Application no: 22/00217/DISC

Location: Begbroke Science Park, Begbroke Hill, Begbroke, OX5 1PF

Lead Local Flood Authority

Recommendation:

**ZONE B CATCHMENT AREAS PLAN**

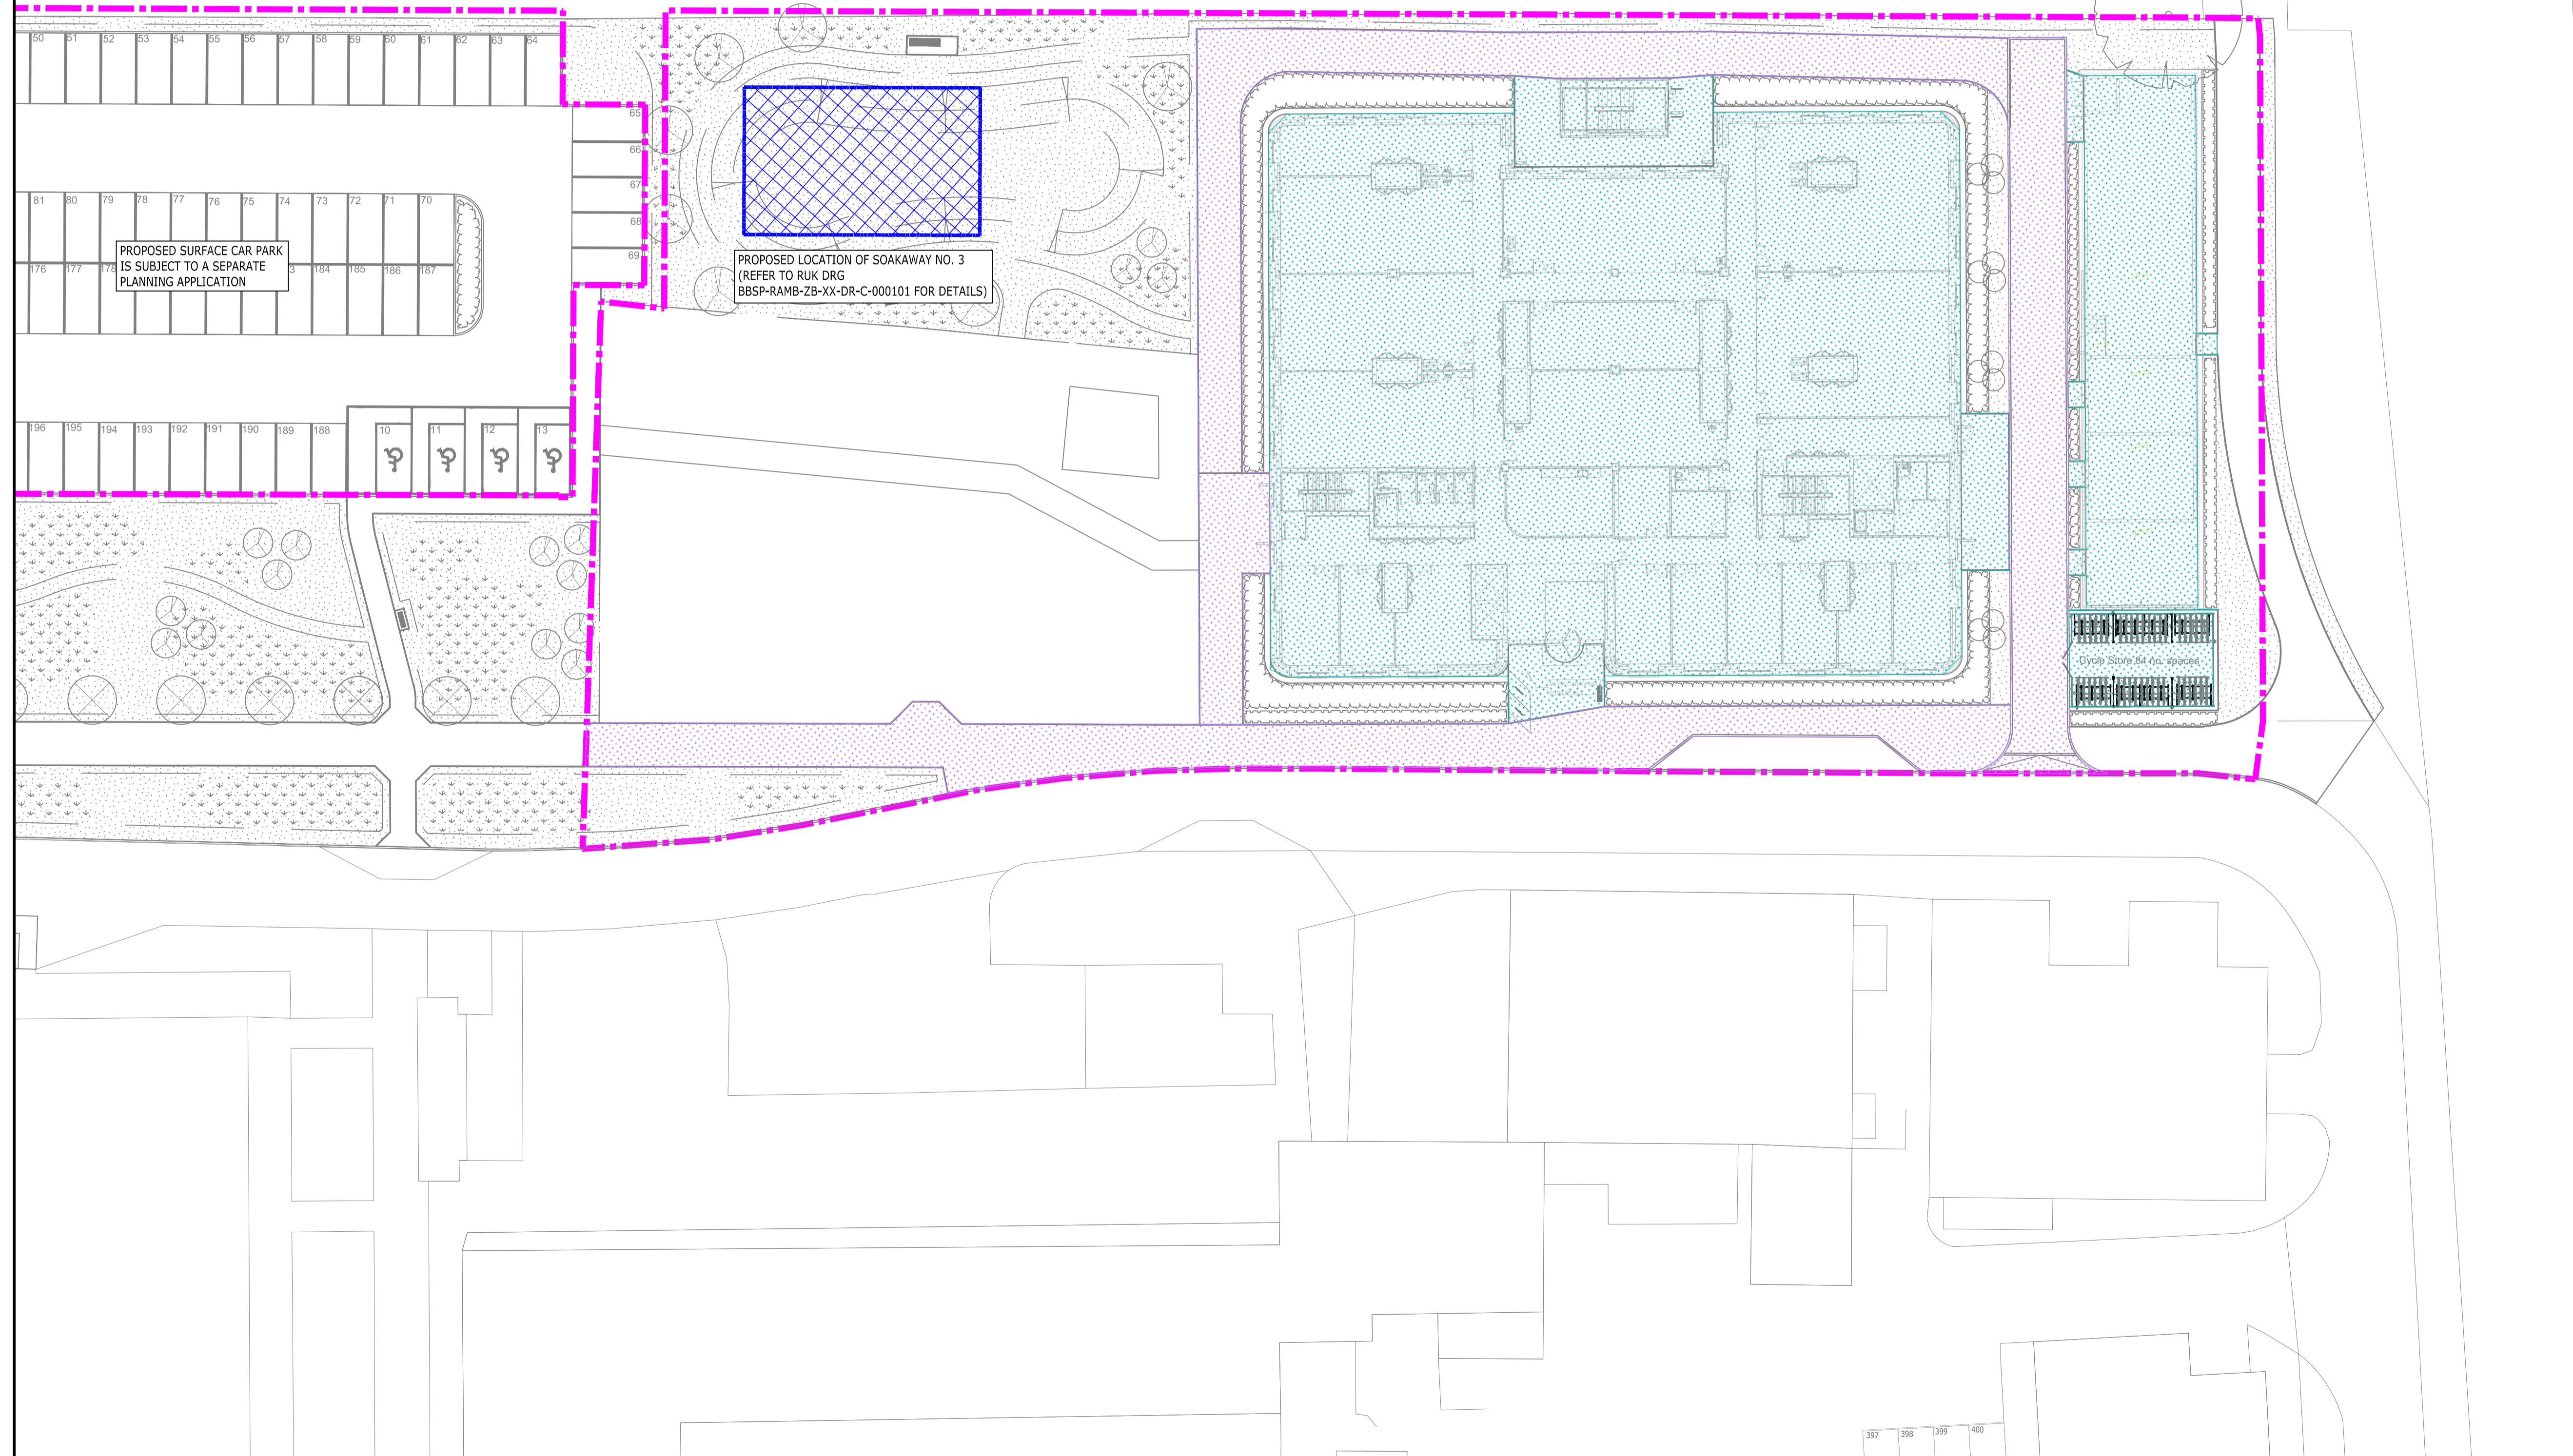
- o Discharge Rates
Red line boundary on the infiltration testing location plan is different compared to the drainage strategy plan and catchment plan. It's difficult to understand the exact locations. Please ensure drawings have the same red line boundary or provide Infiltration testing location on the catchment plan drawing.

- o Infiltration in accordance with BRE365 (To include infiltration testing; seasonal monitoring and recording of groundwater levels)
Red line boundary on the infiltration testing location plan is different compared to the drainage strategy plan and catchment plan. It's difficult to understand the exact locations. Please ensure drawings have the same red line boundary or provide Infiltration testing location on the catchment plan drawing.

**ZONE B INDICATIVE SURFACE WATER DRAINAGE LAYOUT**

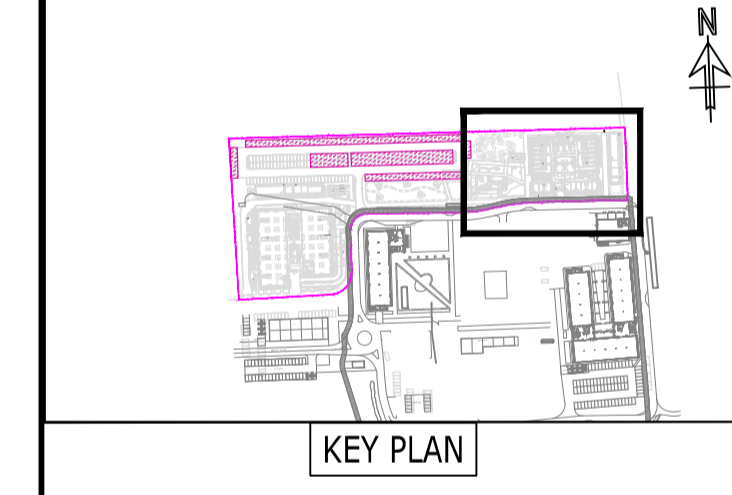
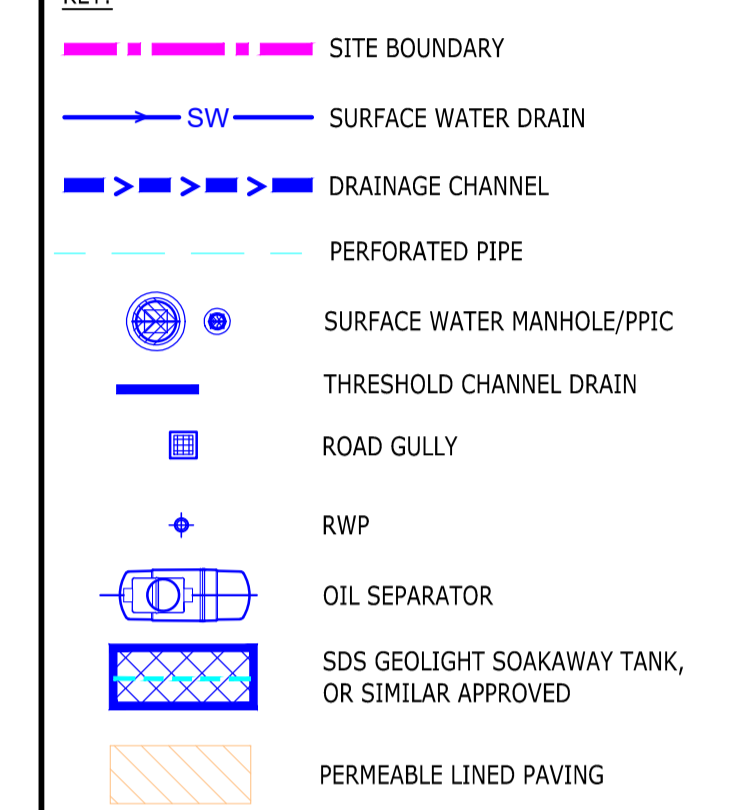
- o Discharge Volumes
Discharged according to: Micro Drainage calculations, 10/09/2021
- o SUDS (Soakaways)
There is a soakaway proposed outside the site boundary, please clarify ownership of this land and whether the proposed soakaway is acceptable.

- o Detailed drainage layout with pipe numbers
Provide pipe numbers. Calculations should reflect the pipe references. Include pipe numbering on the drainage strategy drawings.
